Date: 04-Feb-2026
Our Ref: 2025/93370

**Application for a non-material amendment following a grant of planning permission,
Town and Country Planning Act 1990**

**Non material amendment to previous permission 2021/92062 for erection of 9
dwellings and associated works
adjacent, Britannia Road, Golcar, Huddersfield, HD3 4QB
Application Number: 2025/93370**

01 BOUNDARY WALL (FRONT) - PART ELEVATION & DETAIL SCALE 1:20

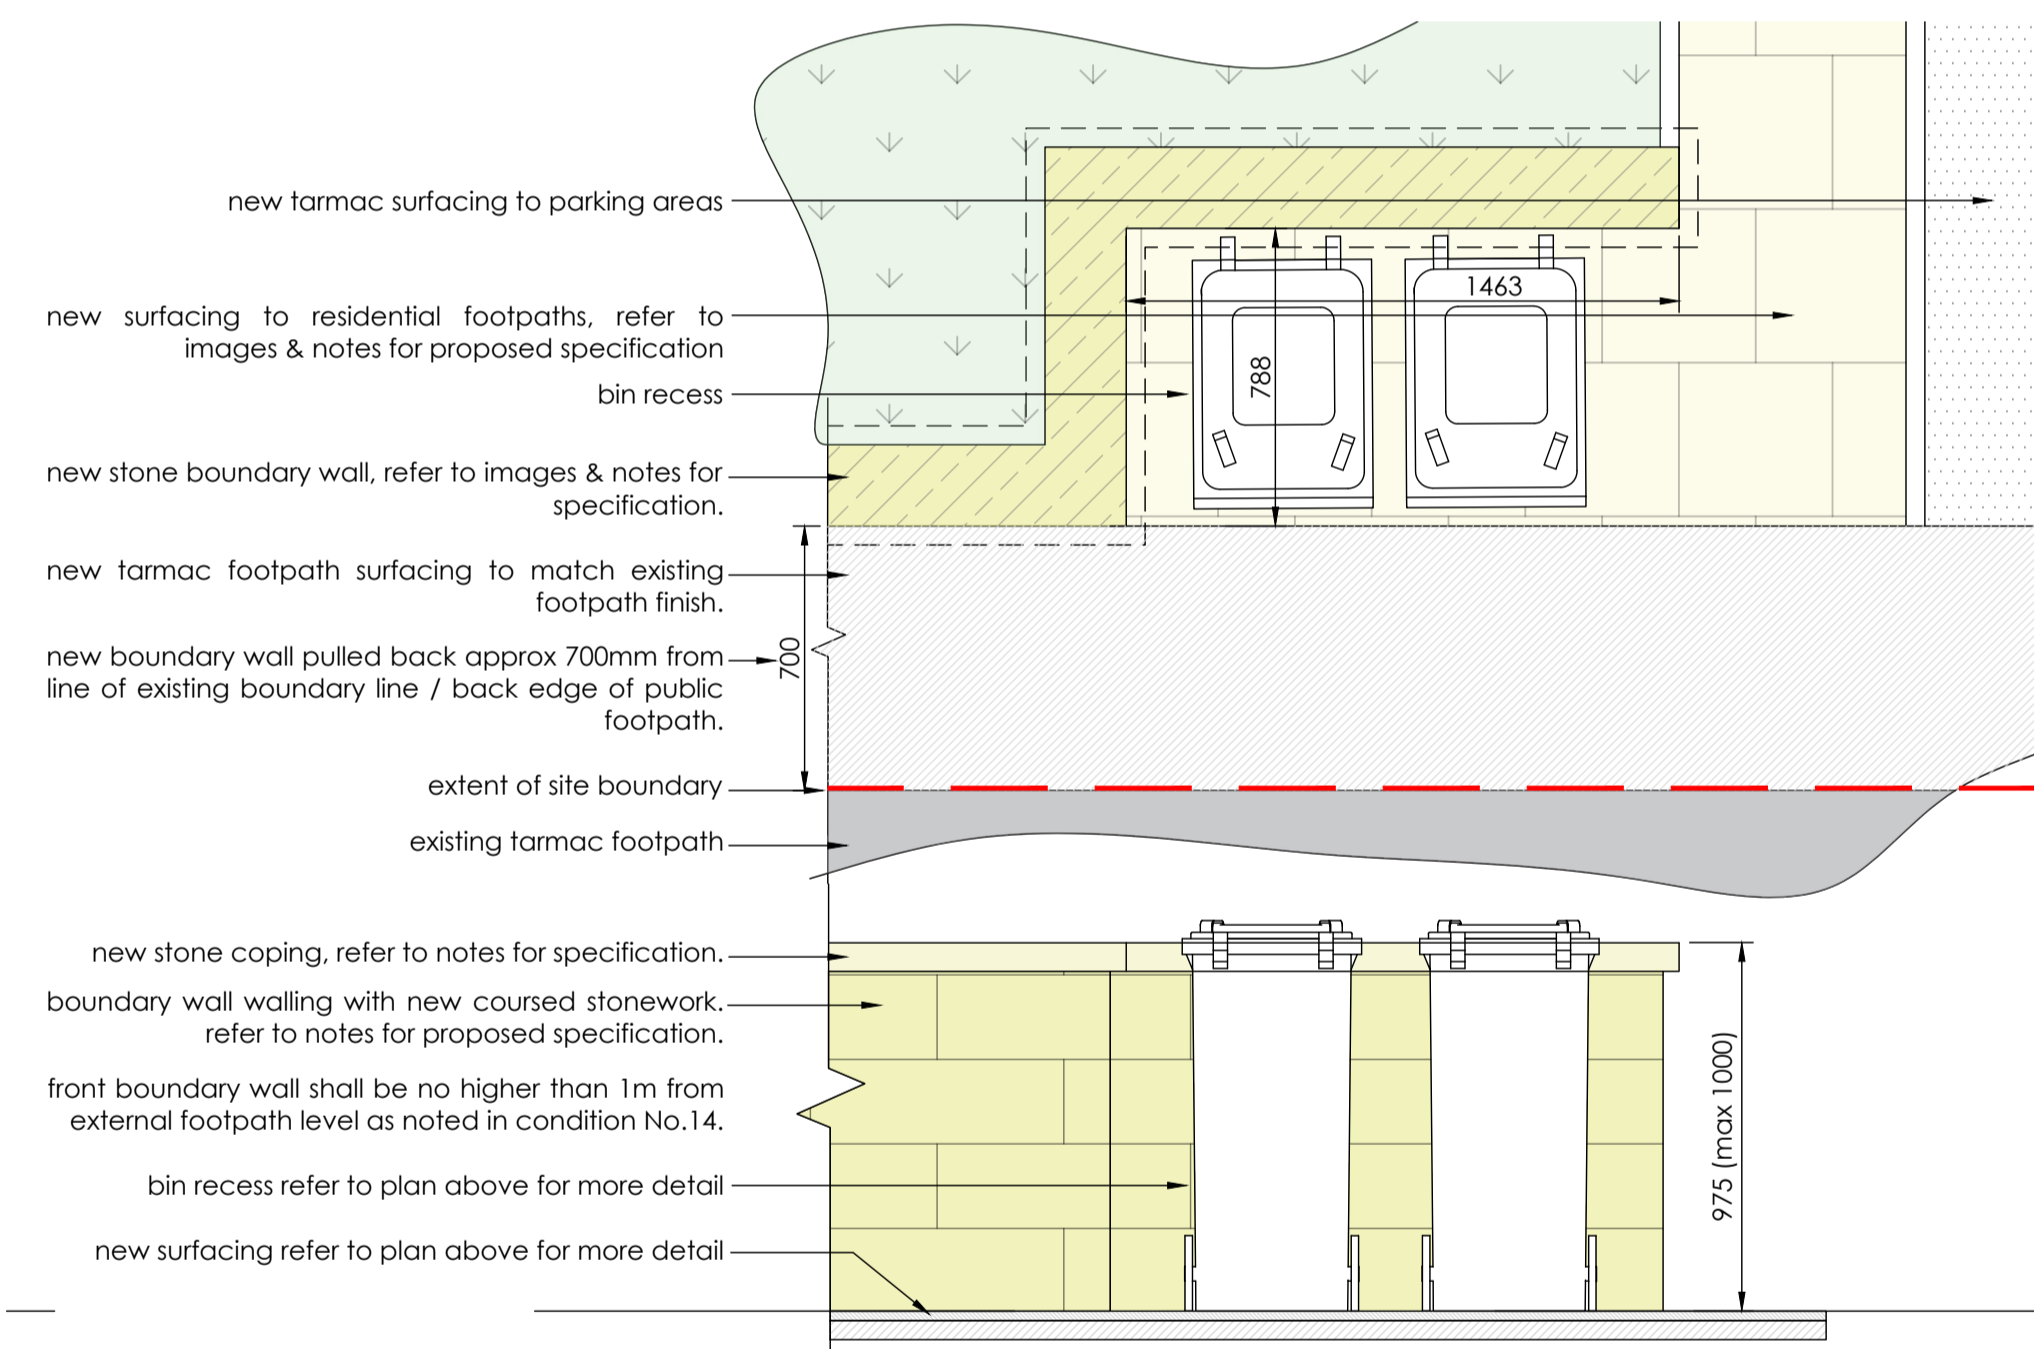
- Modifications to the previously approved retaining and boundary walls to accurately reflect the correct site levels.
- Revision of boundary walling agreed under AIP approval.

- Proposed Site Plan & Boundary Elevations, Drawing No. 100, Rev B, received 08/12/2025.
- Proposed Site Sections, Drawing No. 101, Rev B, received 08/12/2025.
- Boundary Treatment Details, Drawing No. 102, Rev C, received 08/12/2025.
- Proposed Site Location Plan, Drawing No. 106, received 08/12/2025.

14. Boundary treatment and treatment of retaining walls (i.e. facing materials) throughout the site shall be undertaken in accordance with hereby approved

drawing nos. 100, Rev B, 101, Rev B and 102 Rev C, received 08/12/2025. The front boundary wall, adjacent to Britannia Road, shall not exceed 1.0m in height. The dwellings shall not be occupied until the works comprising the approved scheme have been completed and thereafter retained for the lifetime of the development.
